**Recommendation:** Refuse

**Applicant:** Grundon Waste Management

**Proposal:** Certificate of Lawfulness of Existing Use for use of site as depot, workshops, outdoor storage and associated offices.

Historical Maps

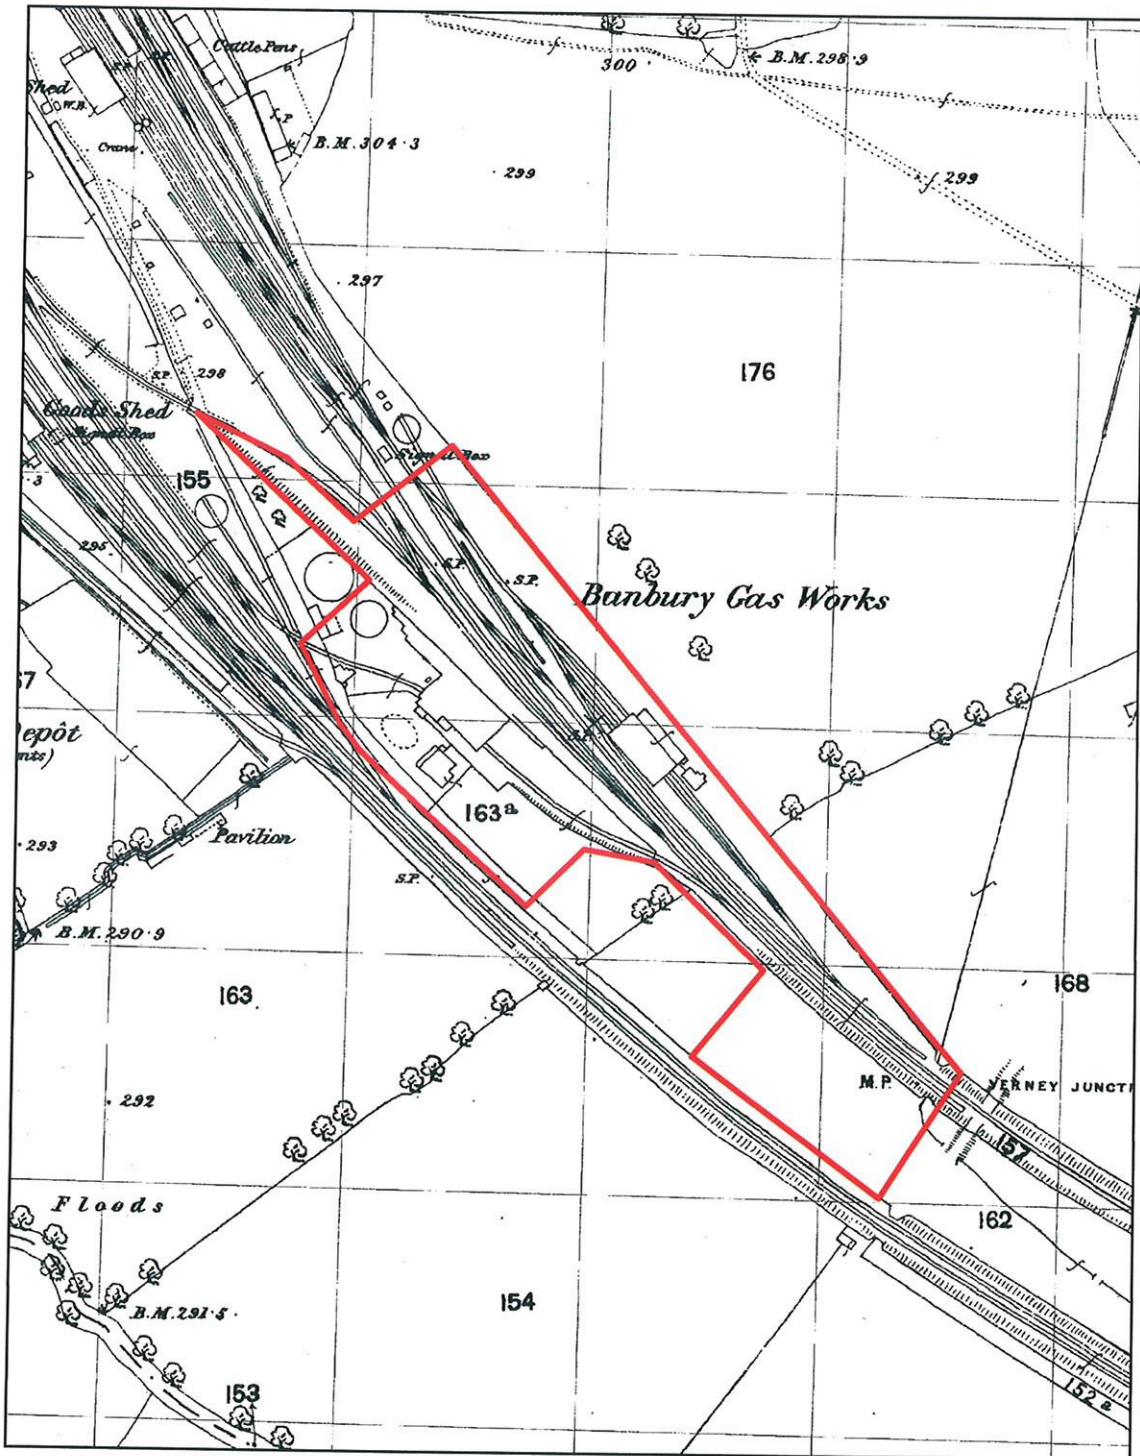
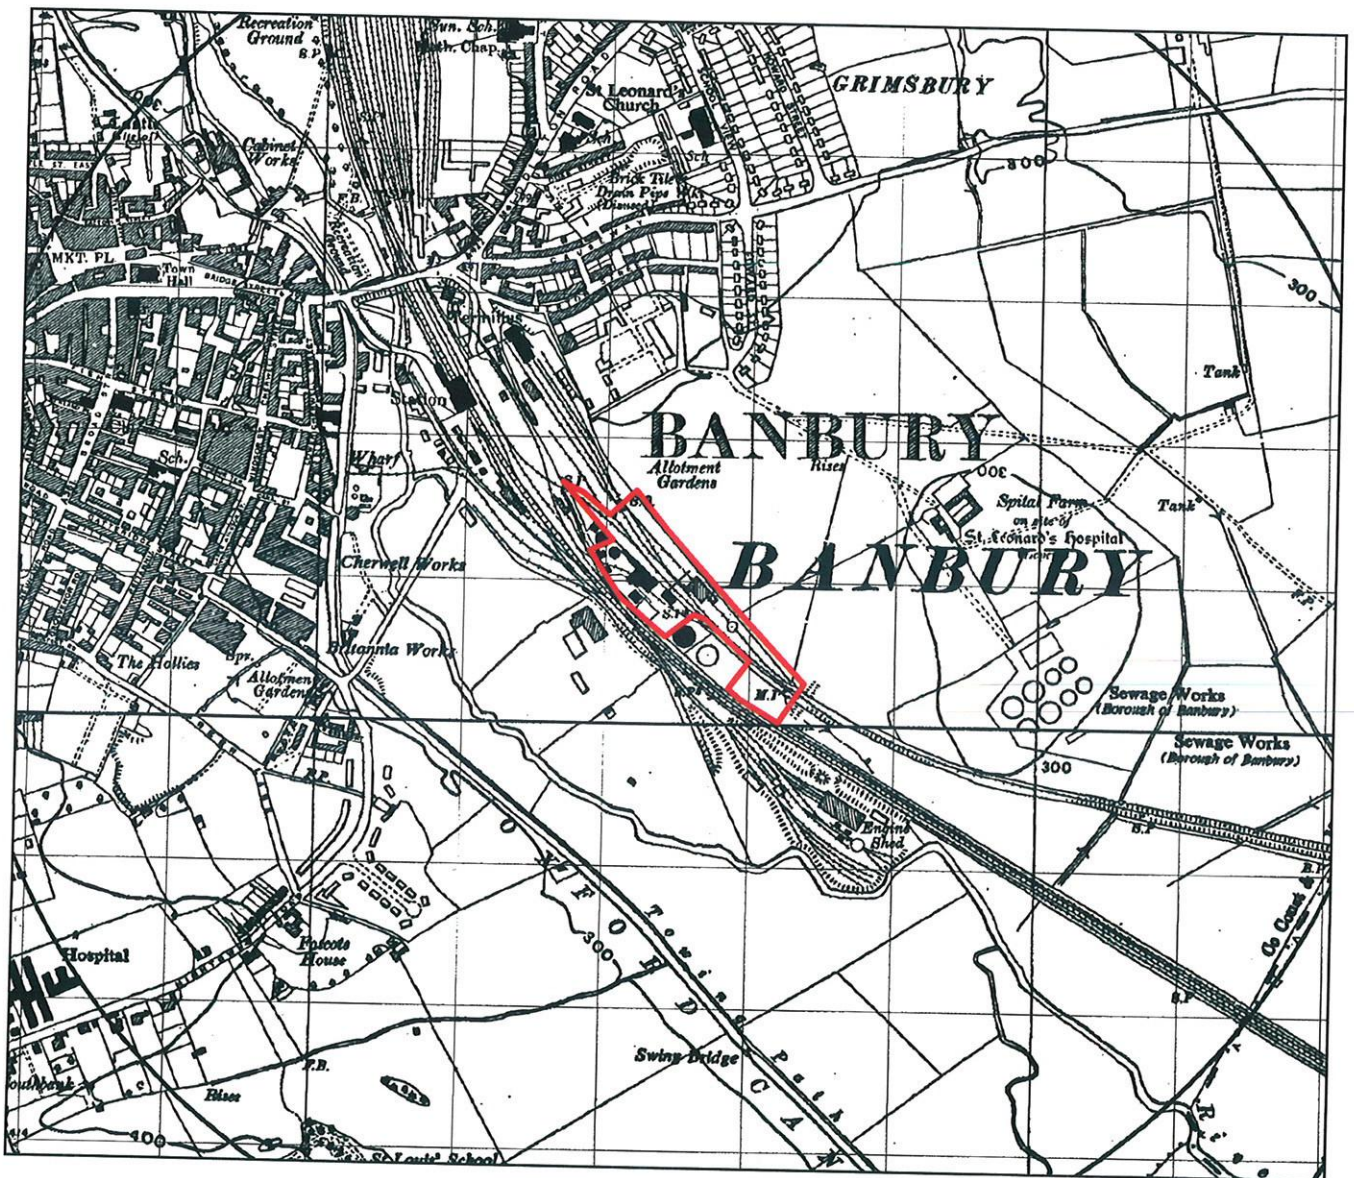
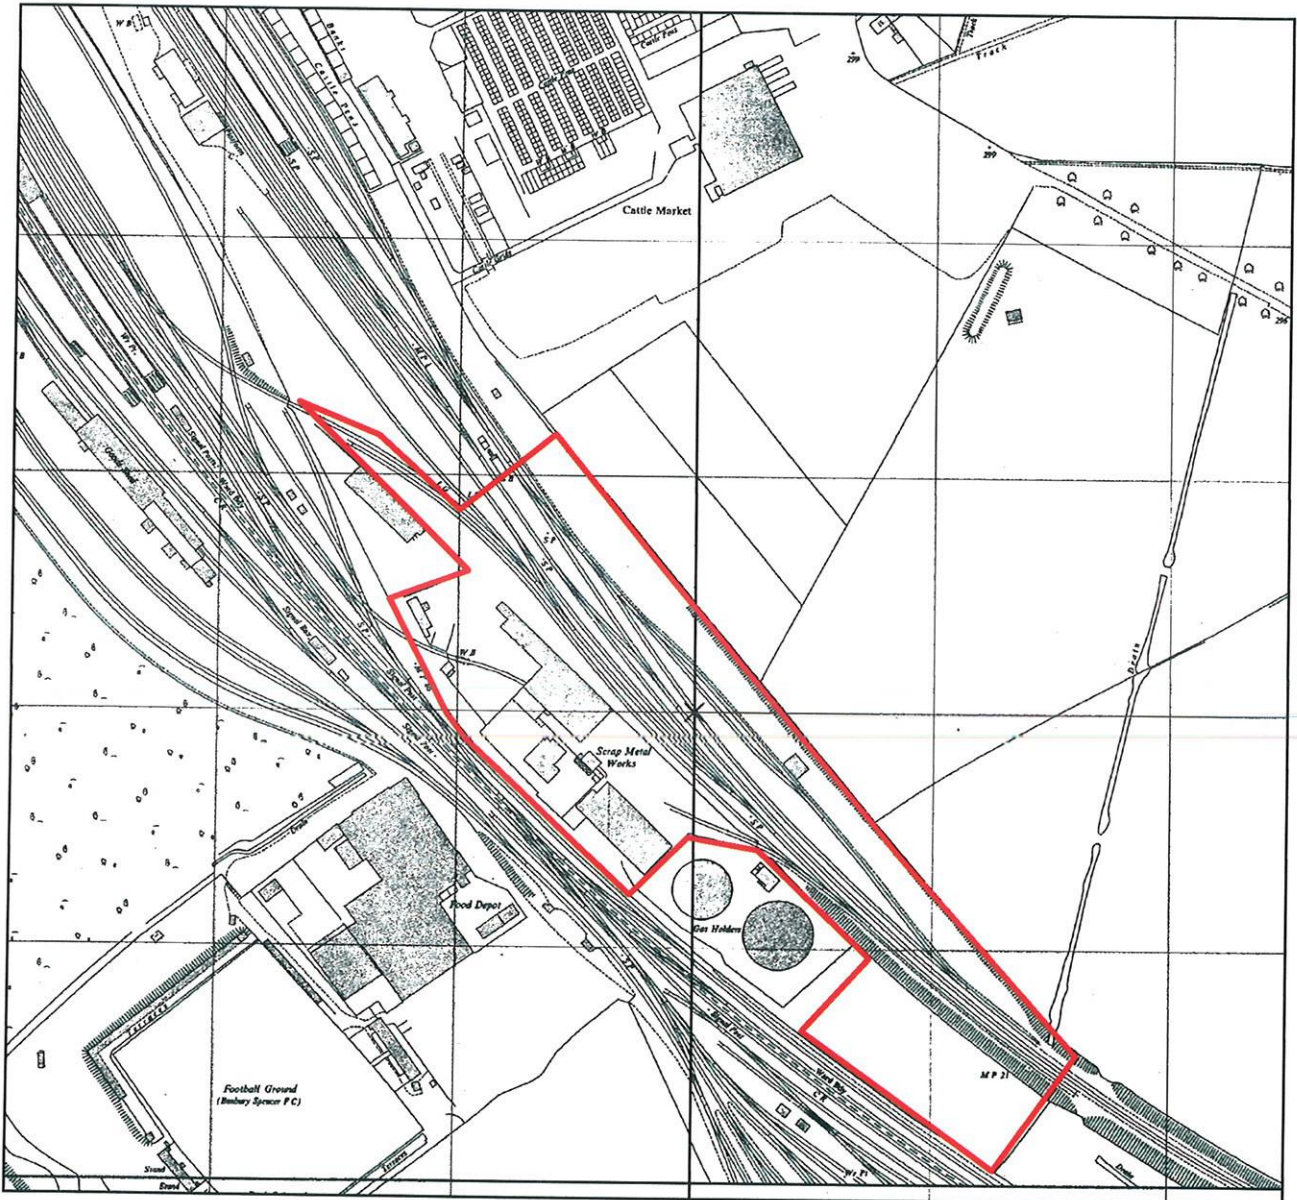
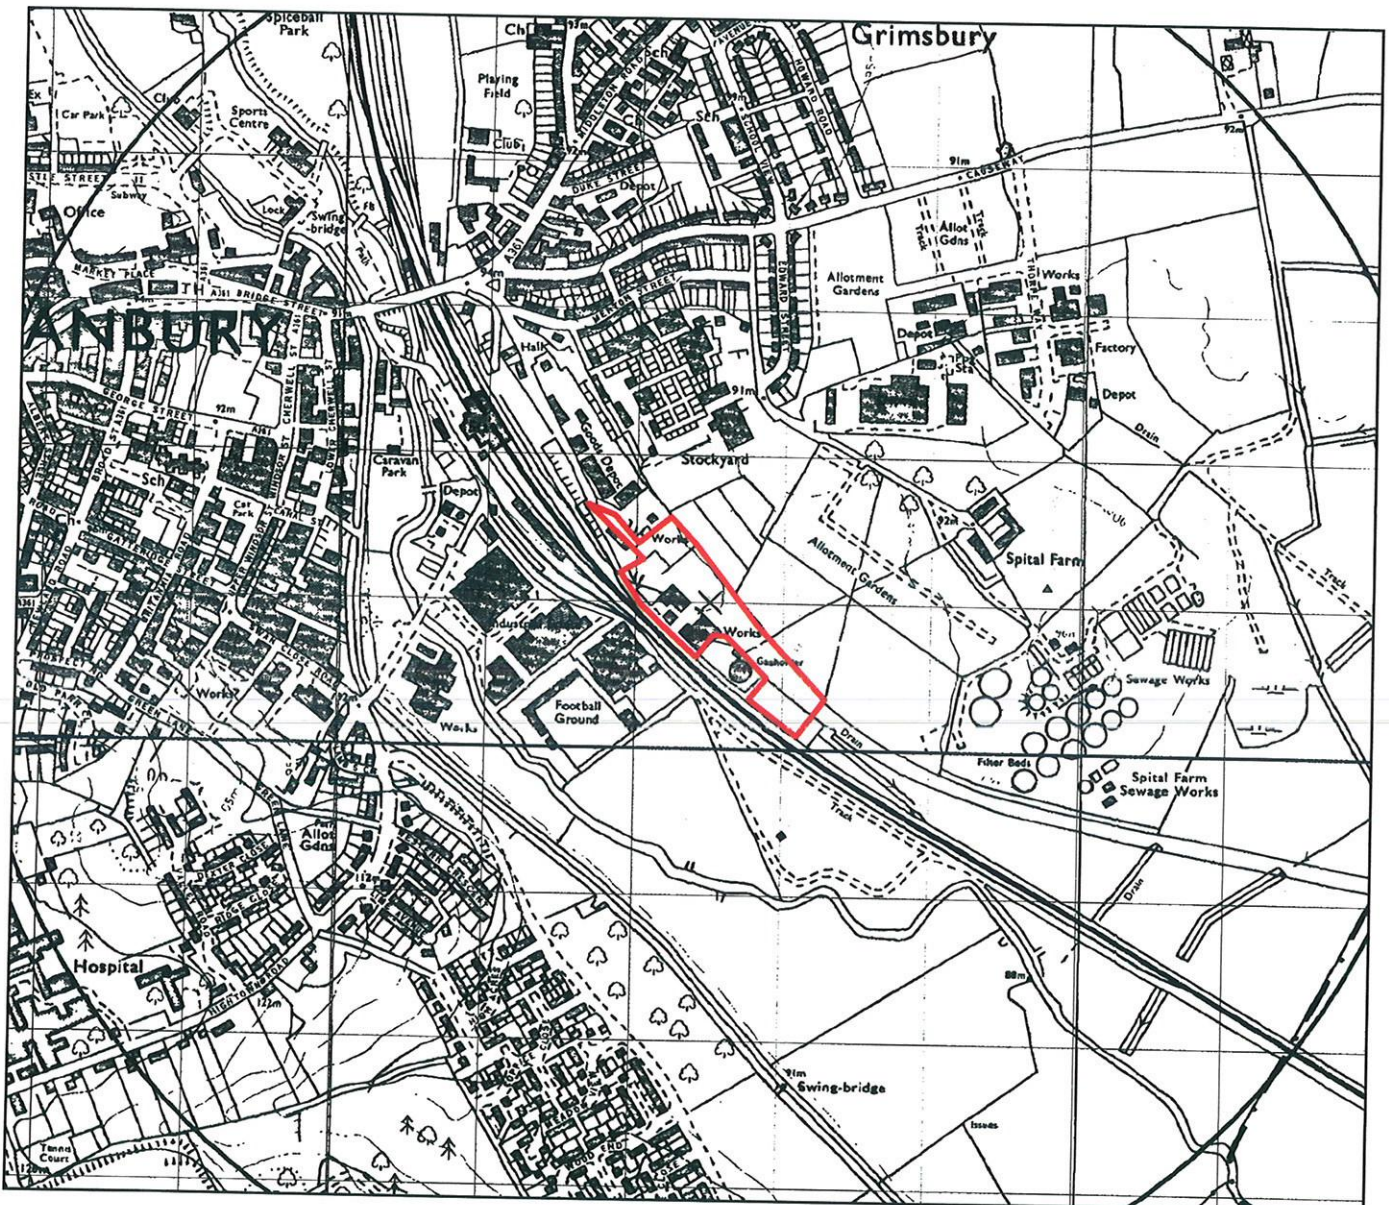
8.18. The historical photographs cover a period between 1885 and 1995 and are therefore prior to the 10-year period required by the application. Furthermore, the maps do not provide sufficient information to conclude a definitive planning use of the site at the time.

S Grundon Services Ltd, Merton Street, Banbury, Oxfordshire, OX16 4RN

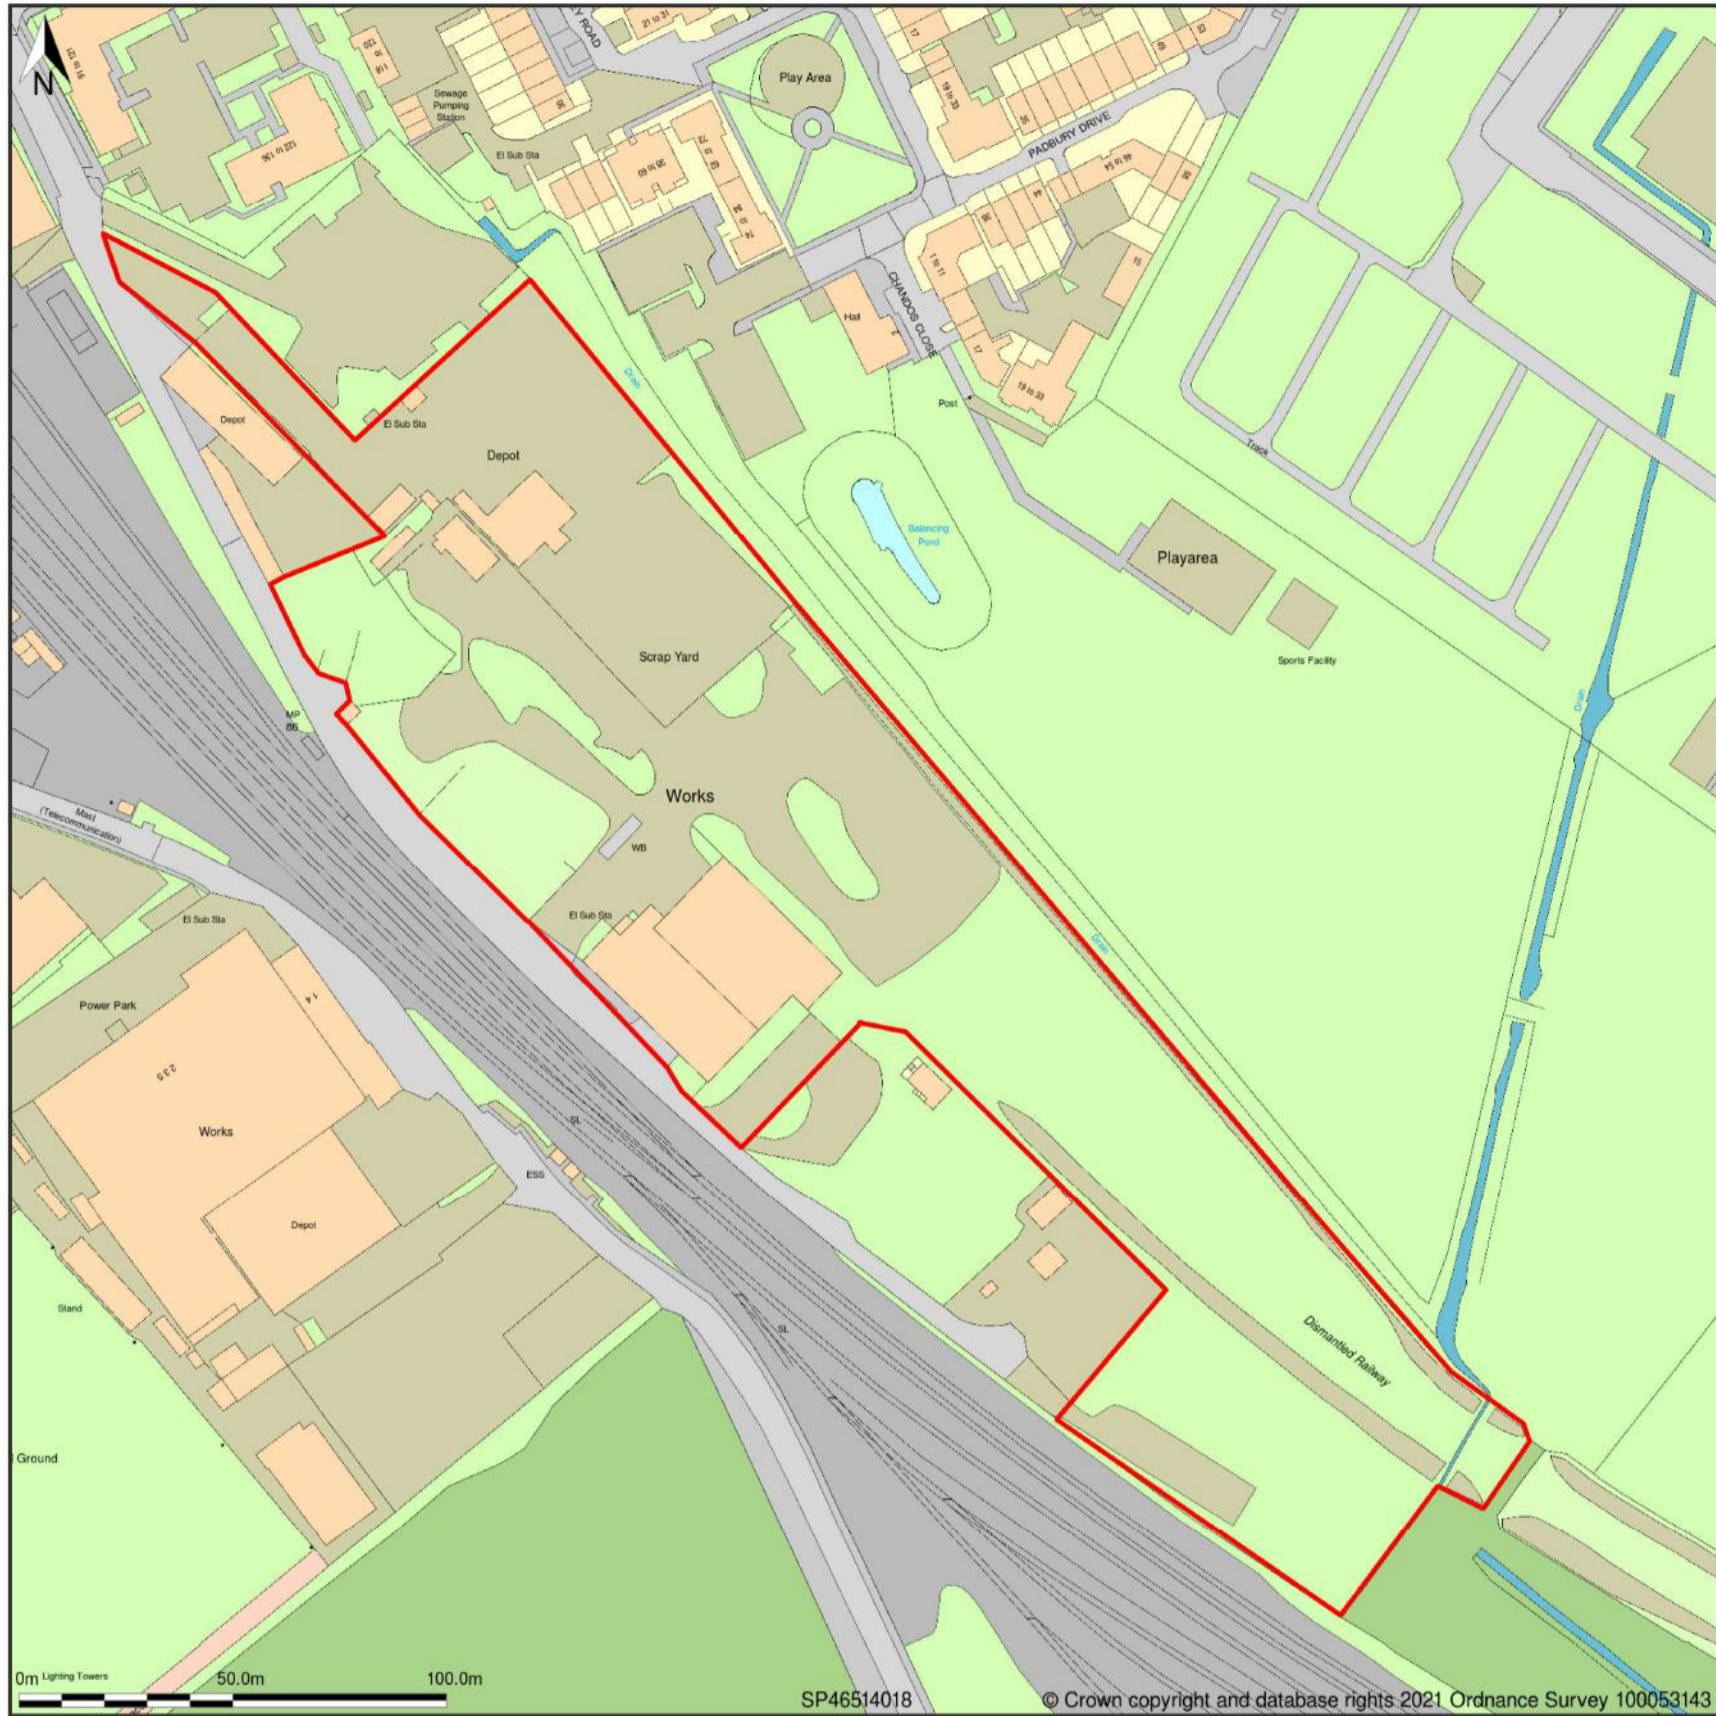
- 8.9. The site plan includes all of the land within the applicant's ownership and does not specify the use claimed for each area. The google map aerial photographs have been annotated but again do not show the extent of land included within each use.
